Development Facilitation Team (DFT) – Review Comments

Project No: PR-2019-002042 Date: 05/21/2025 Agenda Item: #7 Zone Atlas Page: MX-M

Application For: DHOWVR-2025-00016 – DHO WAIVER

Project Name: Sombra Del Oeste Subdivision (just east of 98th and Gibson)

SOMBRA DEL OESTE
EXHIBIT A: WAIVER-DHO DRIVEWAY LENGTH

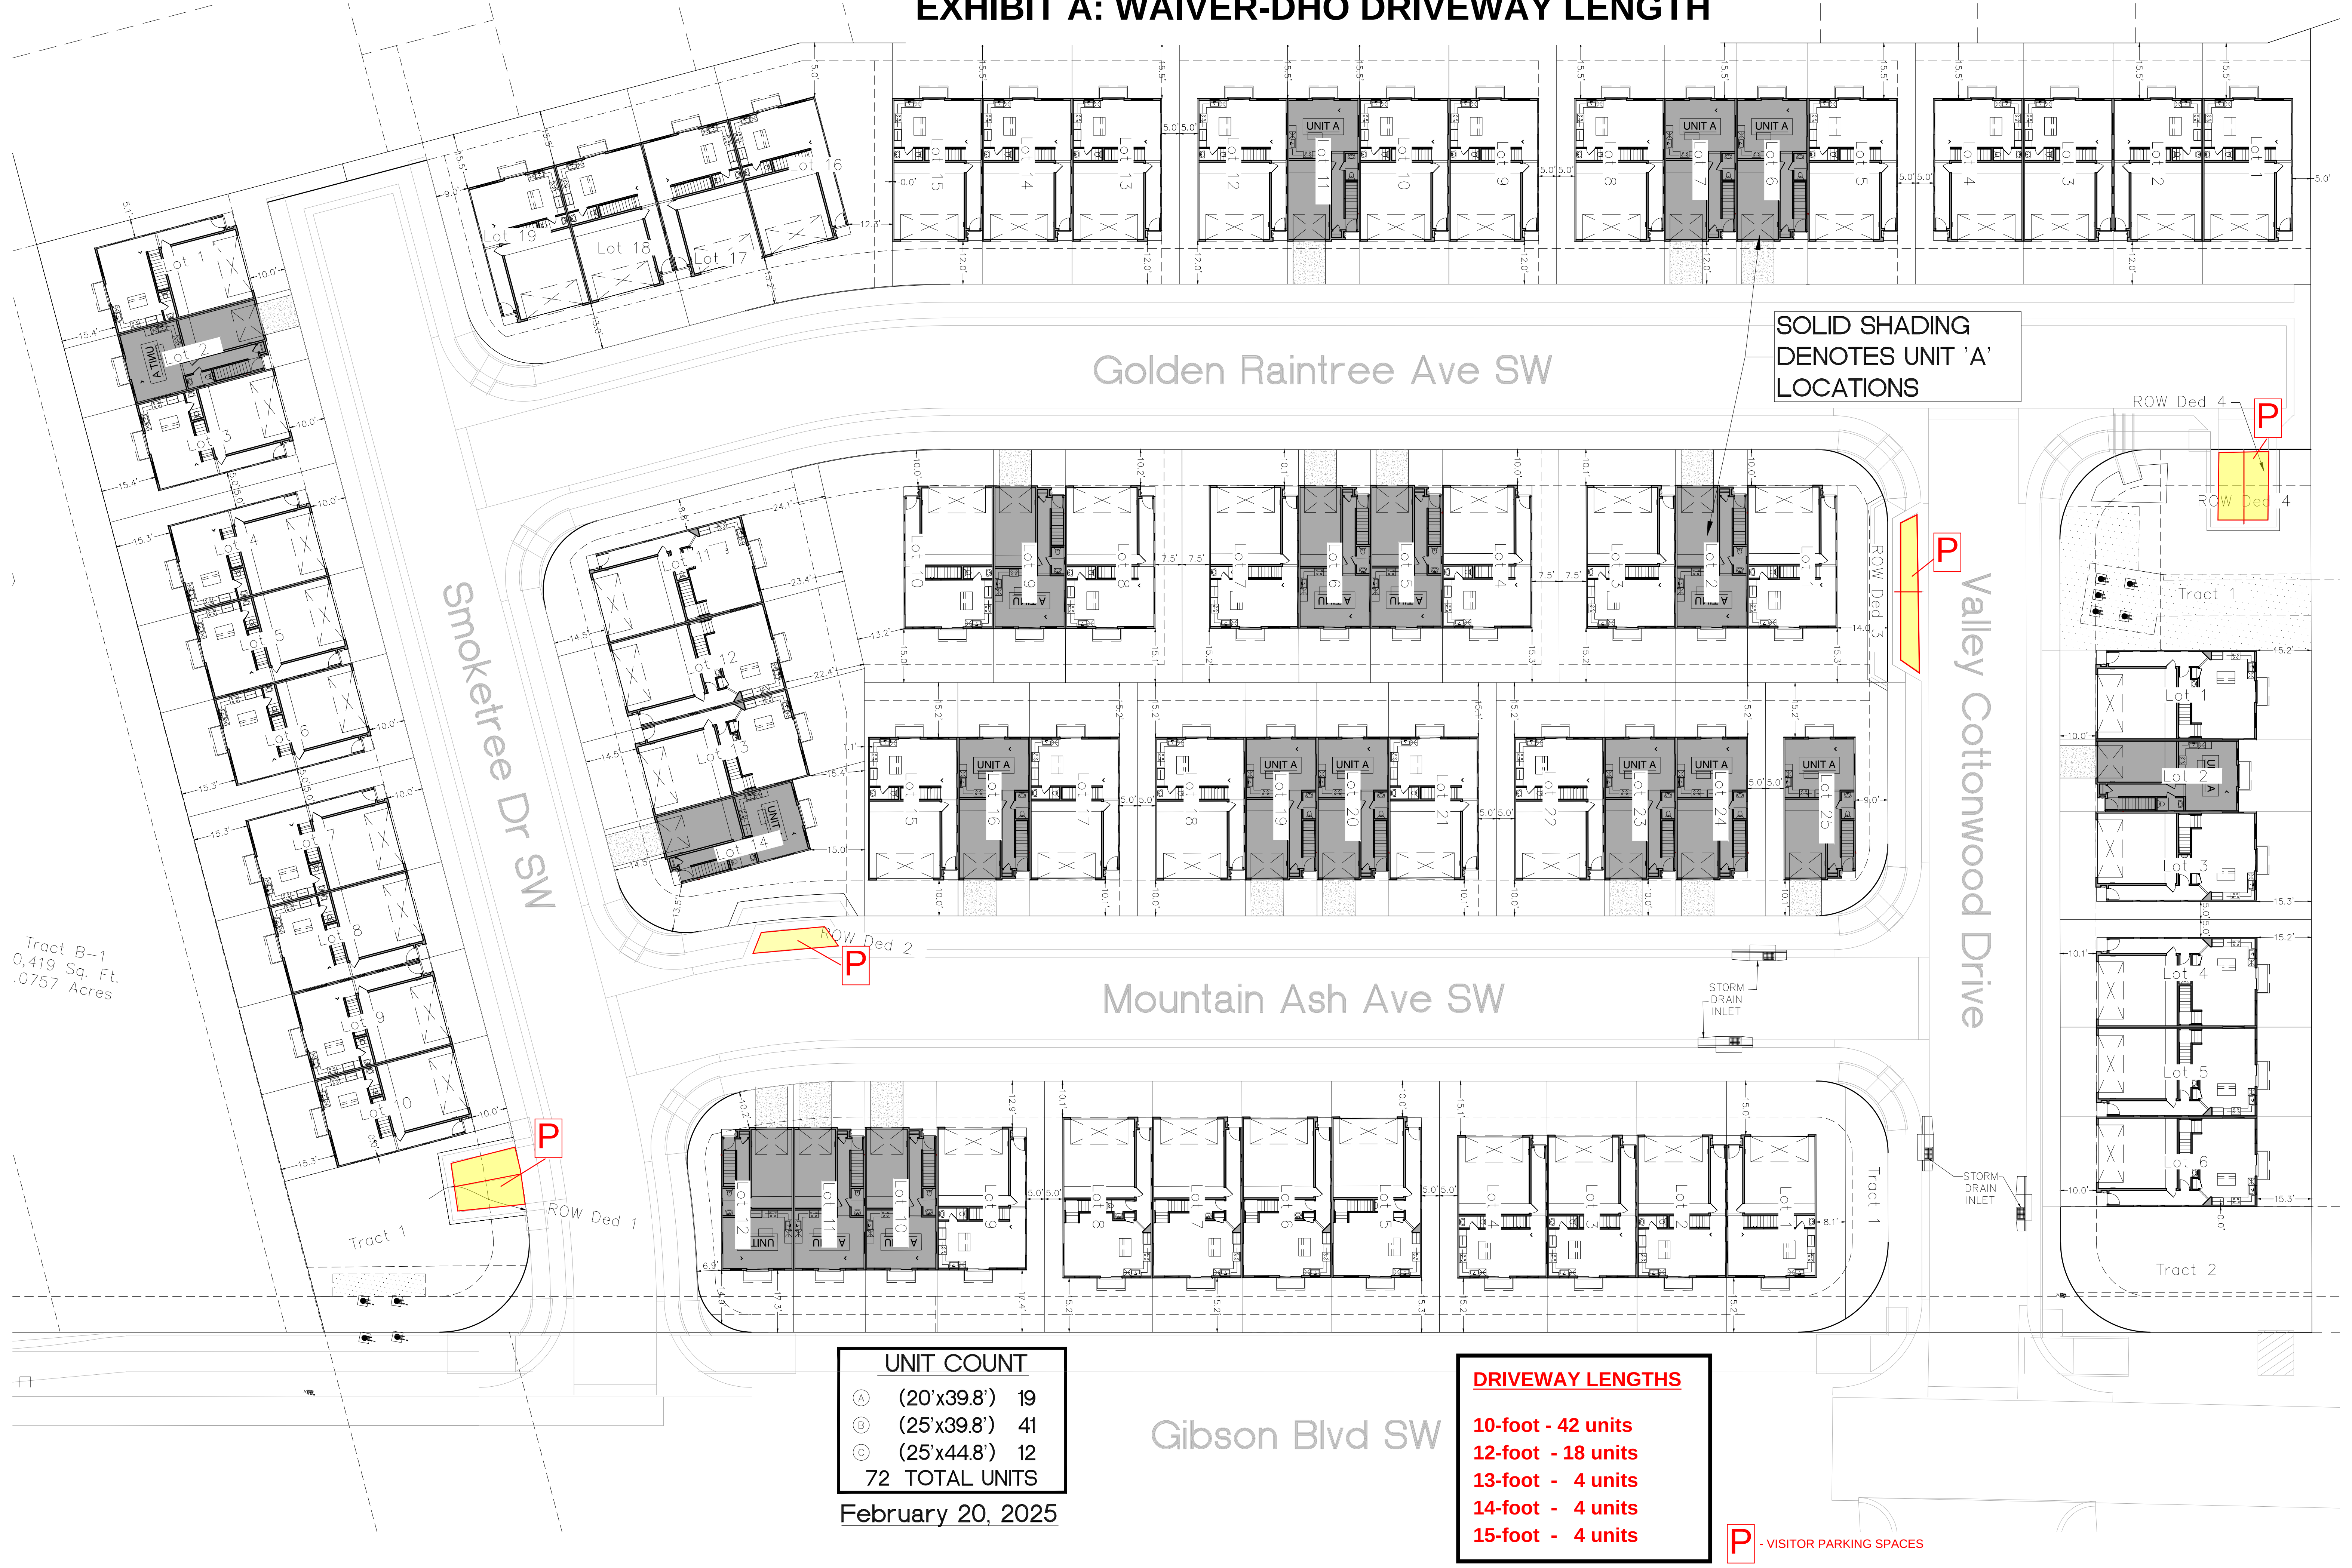
1. Transportation does not support this waiver. Specifically, criteria #9 is not met, as this is not the minimum required to make the site work. This is a new development where the applicant is on control of all aspects of the site design, as such the site should be designed to meet all current standards.

- Planning agrees with Transportation and the City Engineer that the applicant can more effectively explain why this Waiver should be granted. It is not clear as to how this is a unique circumstance and how this would not create a negative impact for the entire development.

- The driveway requirement was noted and mentioned in previous pre-application and platting action review memos. In addition, several other subdivision sites have had complaints related to the development of shorter driveways that resulted in parking violations, zoning code violations, and/or an encroachment that crosses or blocks public right-of-way area.
- An alternative solution would be to submit a ZHE variance request to the rear setback requirement. This would potentially allow the proposed floor plans to proceed while meeting all other dimensional standard requirements.
